Yorkshire Water Services
Developer Services
Sewerage Technical Team
PO BOX 52
Bradford
BD3 7AY

Your Ref: 2024/91998
Our Ref: A003873

21st August 2024

former, Almondbury High School, Fernside Avenue, Huddersfield, HD5 8PQ – Erection of special educational needs and disabilities school (Use Class F1), comprising educational buildings, roof mounted photo-voltaic panels, sensory garden spaces, multi- use games areas, landscaping, hardstanding areas, carparking, access with secure fencing and associated ancillary development

Appendix 7: Proposed Outline Levels and Proposed Drainage Layout

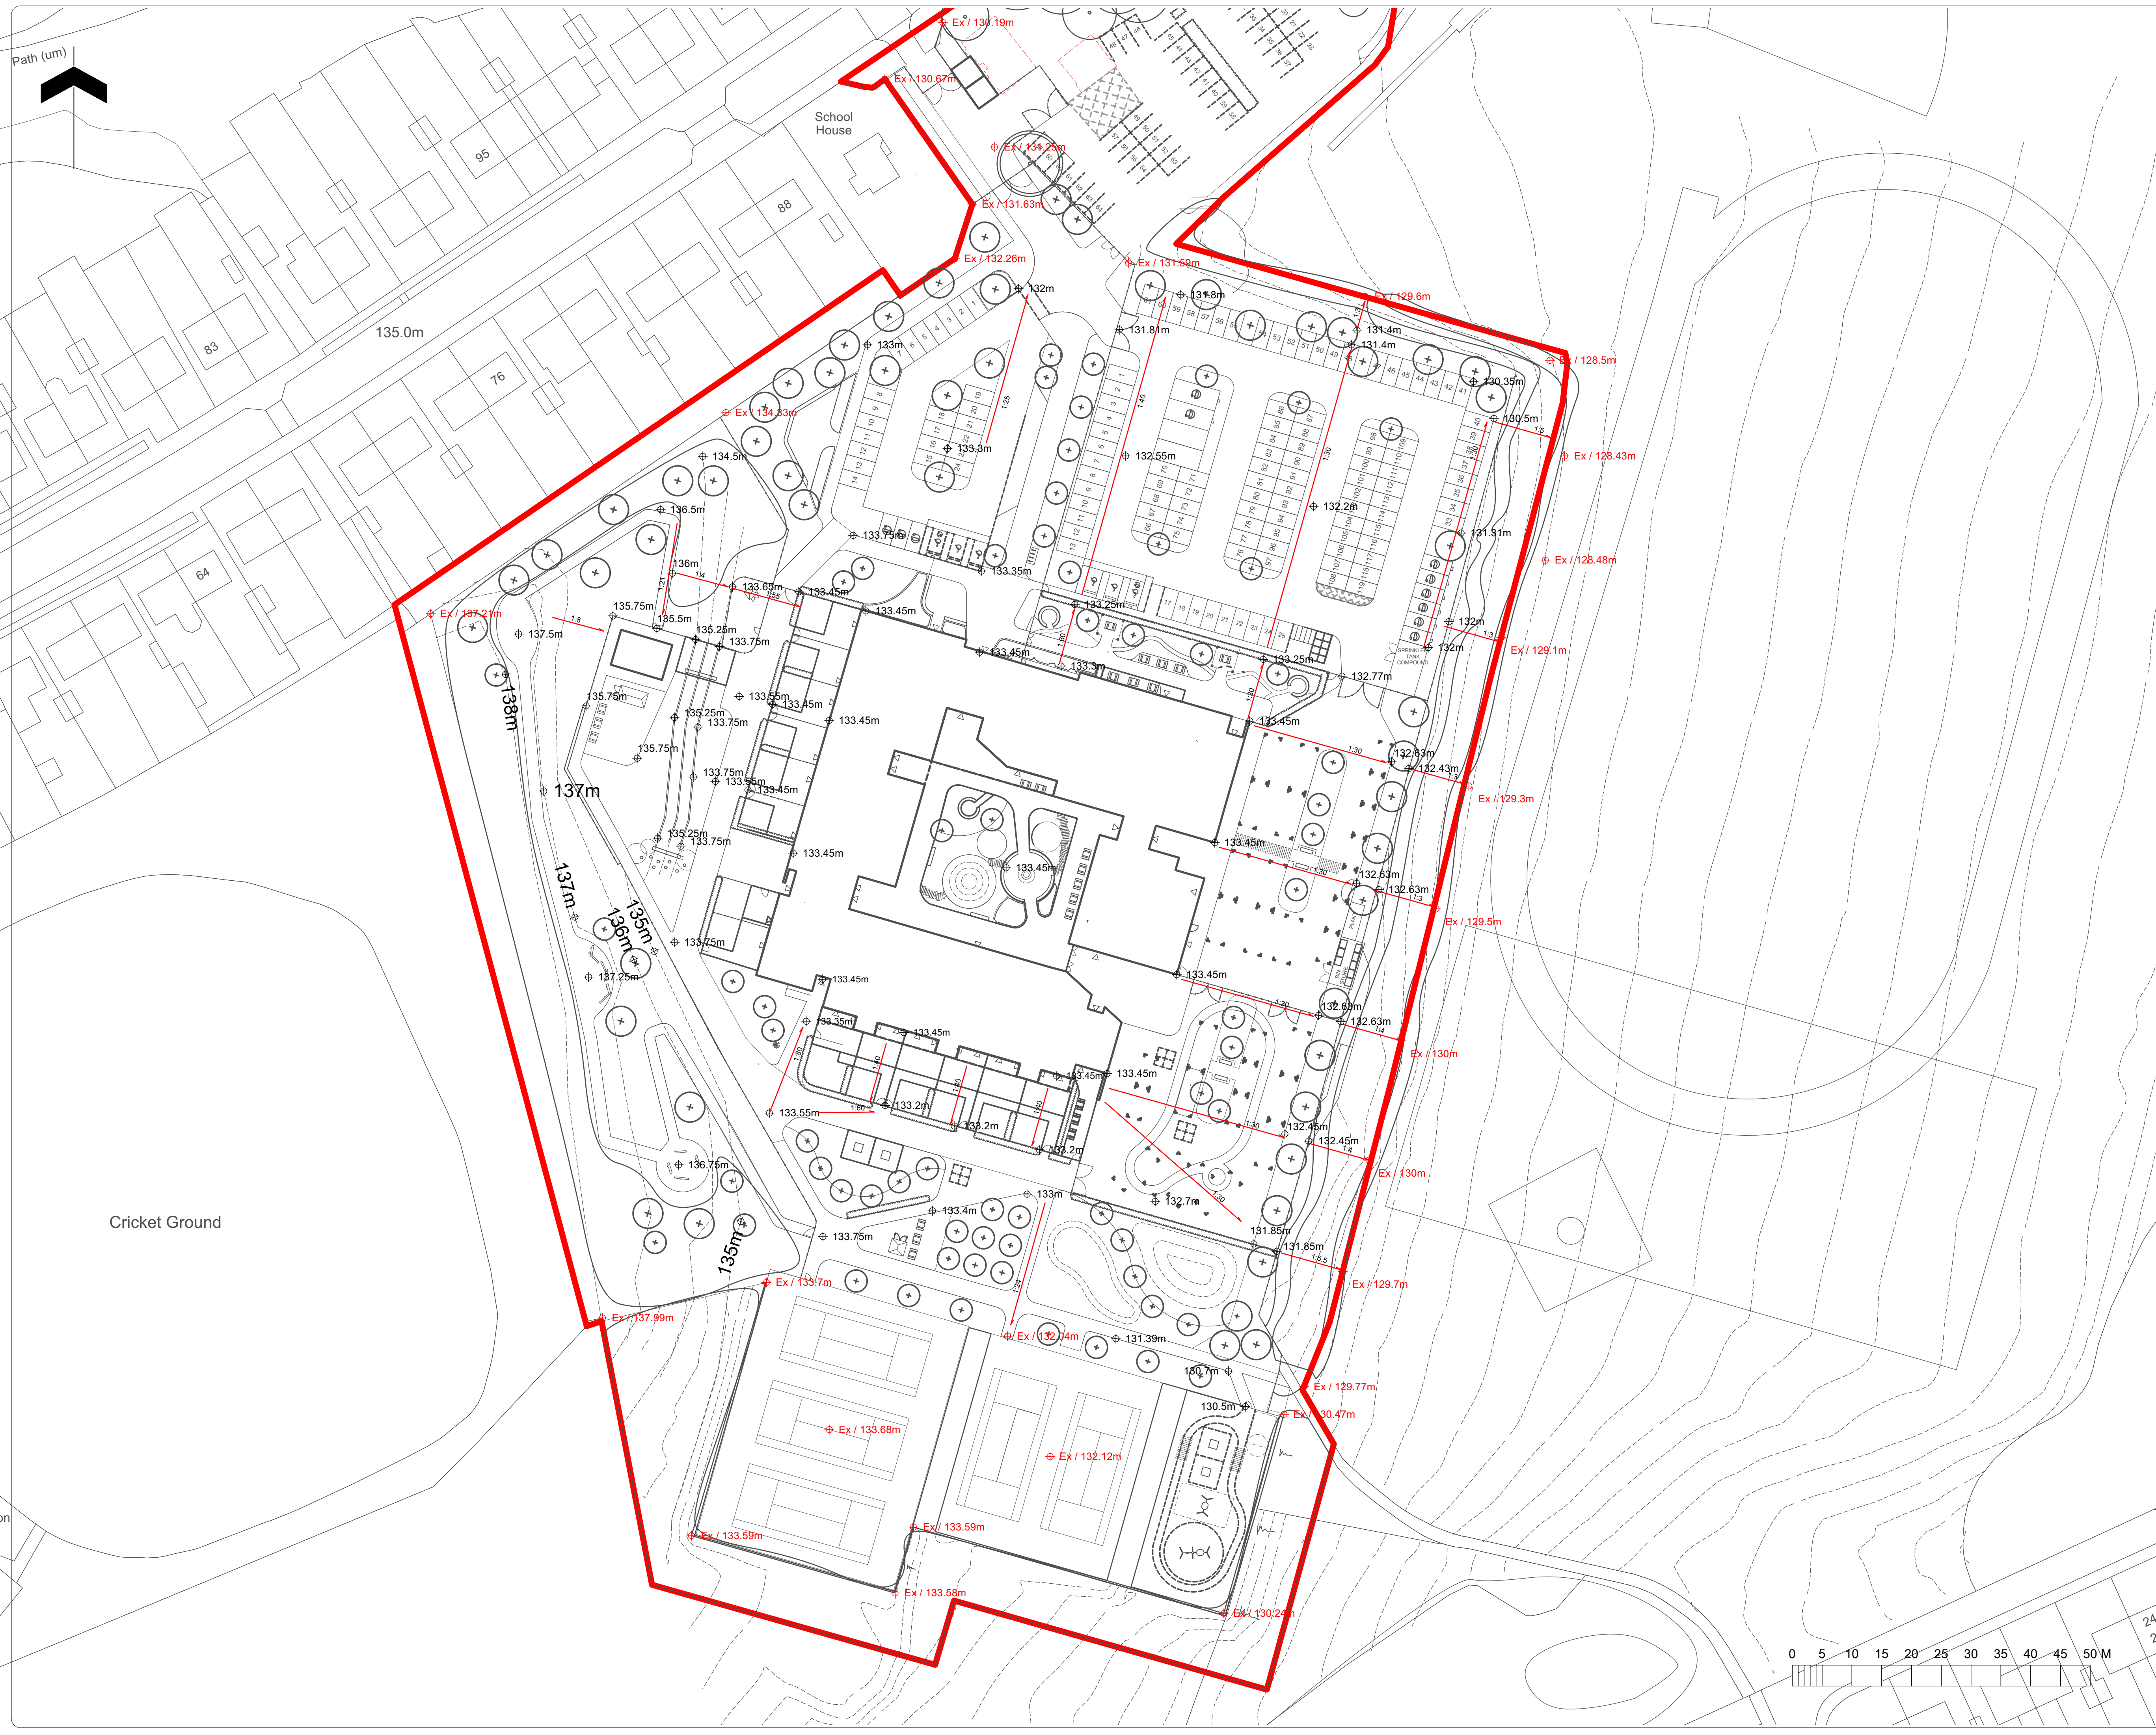
1.) The submitted 'FLOOD RISK ASSESSMENT & OUTLINE DRAINAGE STRATEGY' FRA 22 1180 (version R0) prepared by LK Consult, dated February 2022 requires amendments, but if planning permission is granted, the matter can be dealt with via condition.

- a.) Foul water will discharge to public combined water sewer
- b.) Sub-soil conditions likely do not support the use of soakaways, however infiltration testing has yet to be carried out.
- c.) A watercourse is remote from the site
- d.) Surface water will discharge to public surface water sewer via storage with restricted discharge of 3.5 litres/second.
- e.) The means of surface water management has not been properly considered within the FRA/drainage report. Yorkshire Water requires further information regarding the means of draining surface water from the development

2.) The developer is proposing to discharge surface water to public sewer however, sustainable development requires appropriate surface water disposal.

- a.) Yorkshire Water promote the surface water disposal hierarchy and the developer must provide evidence to demonstrate that surface water disposal via infiltration is not reasonably practical before considering disposal to public sewer.

- b.) The developer and LPA are strongly advised to seek comments on surface water disposal from other drainage bodies as further restrictions may be imposed.
- c.) As the proposal site is currently undeveloped, no positive surface water is known to have previously discharged to the public sewer network. Surface water discharge to the existing public sewer network must only be as a last resort and the developer is required to eliminate other means of surface water disposal.
- d.) As a last resort, and upon receipt of satisfactory evidence to confirm the reasons for rejection of other methods of surface water disposal, curtilage surface water may discharge to public surface water at a restricted rate not to exceed 3.5 litres per second.

- i) evidence that other means of surface water drainage have been properly considered and why they have been discounted; and**
- ii) the means of discharging to the public sewer network at a rate not to exceed 3.5 litres per second.**
